From: Ella Pope [REDACTED]
Sent: 15 December 2011 15:16
To: Janice Chapman
Cc: [REDACTED]
Subject: Bramble Barn
Attachments: Bramble Barn planning first draft-DPA-01.pdf, Bramble Barn planning second draft-DPA-01.pdf

PROPOSED ROOF PLAN SCALE 1:100

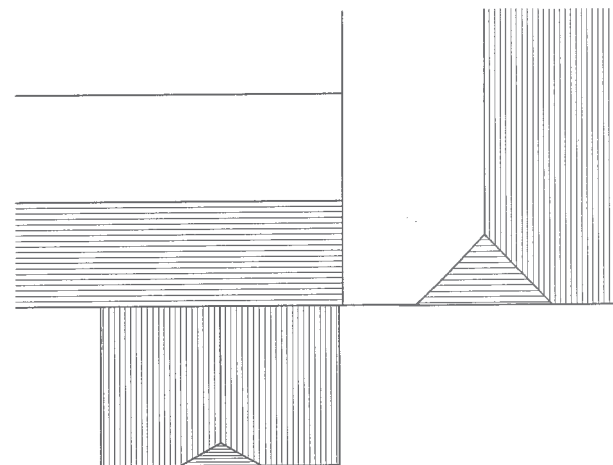
draft one is as agreed with the Client, showing a pitched slate roof (which is drawn at 30 degrees to ensure the new garden room comes in lower than the existing roof), with a small hip and 500mm masonry corners to match the existing masonry.

PROPOSED ROOF PLAN SCALE 1:100

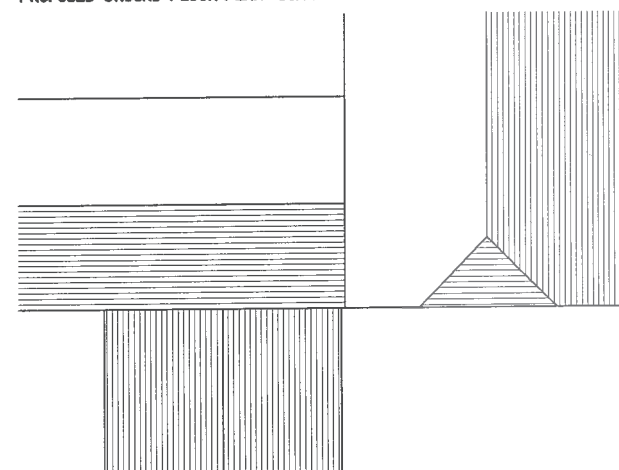
draft two is a development of draft one, showing a pitched slate roof at 33 degrees (we believe the steeper pitch looks better, this could be done on draft one as well, if draft one is preferred), which is the steepest we can go to keep it below the existing ridge line. The hip has been removed, the masonry has been increased.

PROPOSED REAR (SOUTH) ELEVATION SCALE 1:100

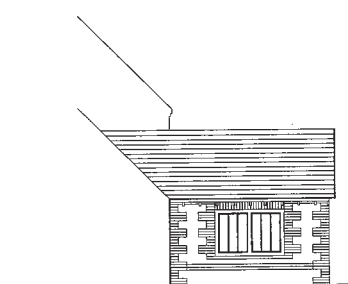
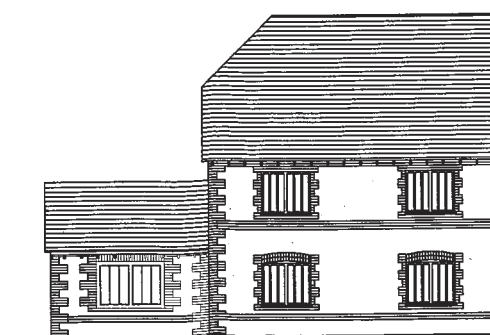
By increasing the masonry, we have been able to better reflect the original brick work pattern, and this has resulted in reduced window sizes on the east and west elevations, whilst giving us the opportunity to improve the glazing on the south elevation - the south elevation shows glazing going into the gable, allowing the internal roof structure to be revealed, providing an elevation which helps enhance the existing elevation and perhaps more in keeping with the vernacular style.
